17 June 2019

File No: 2019/291031  
Our Ref: R/2018/4/D  
Your Ref: SSD 9249 MOD 2

**Exhibition of Modification Request for Sydney Football Stadium Redevelopment  
40-44 Drivers Avenue, Moore Park (SSD-9249-MOD-2)**

Figure 4.2: Sydney Water Diversion Plan showing existing stormwater main (thin blue line), and proposed (thicker blue line) (Source: Aurecon 2019, DWG-CC-00041-B, 25.4.19)

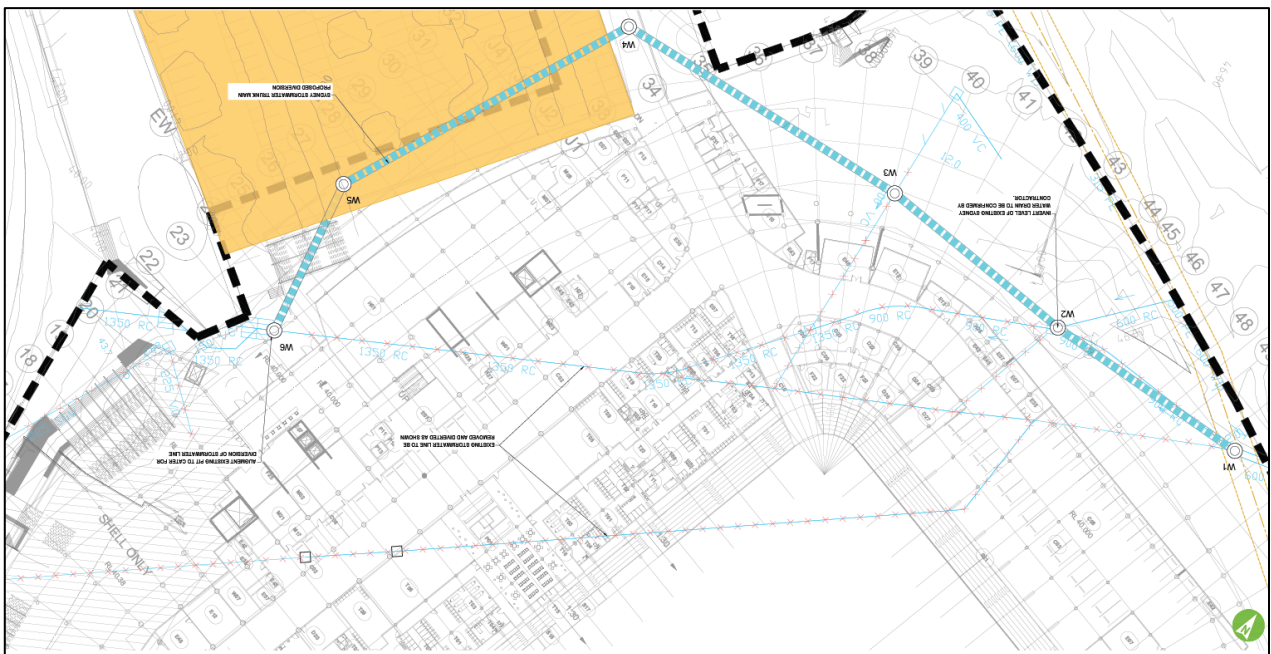
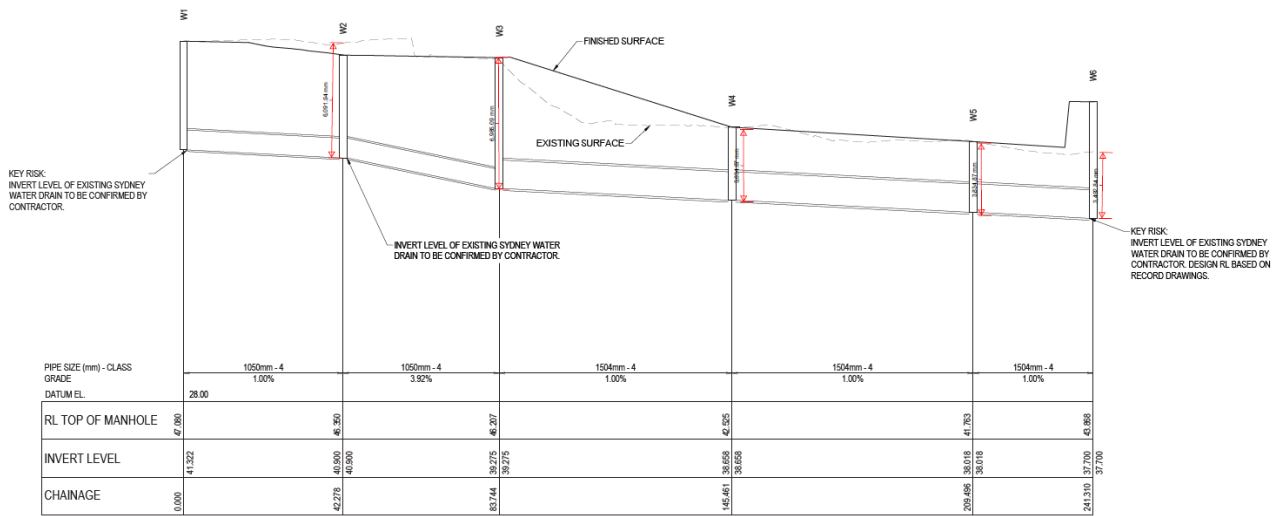
The diversion of the existing Sydney Water stormwater main will involve connecting the new pipe to the existing pit and constructing a new main to the west of the proposed stadium. These works are required to ensure the demolition of buildings approved within SSD 9249 do not impact the existing stormwater servicing through the site. The existing stormwater drain through the site will be decommissioned and removed following installation and commissioning of the new drain.

Due to the size of the storm water installation and depth it is envisaged a 30T excavator will be based on site to do the excavation, bedding and installation of pipe. For pipe sizes 1050mm/1500mm the excavation strategy will require the use of heavy-duty shoring box for excavations deeper than 2.5m. Excavations less than 2.5m will be benched out in accordance with the relevant code of practices.

In addition to the above, a revised Construction Soil & Water Management Plan should be provided which includes information as to how water from the detention /settling ponds will be tested prior to discharge into the stormwater infrastructure in Driver Avenue to ensure that it meets applicable standards.

It is recommended a Dewatering Management Plan (DMP) be prepared to ensure that there are no contaminants prior to being released into the stormwater infrastructure. The DMP must clearly state that the water quality monitoring will be self-certified by an experienced water quality expert. Water is to be tested prior to discharge. There should also be a name and contact point for the site manager and water quality expert monitoring the discharge. The water quality expert monitoring the site is to sign and date water testing – stating that the water quality meets the above mentioned standards. If testing finds that it does not meet these standards discharge must be stopped immediately. The water quality expert is to clearly state in the final report that they believe all discharge met water quality standards.
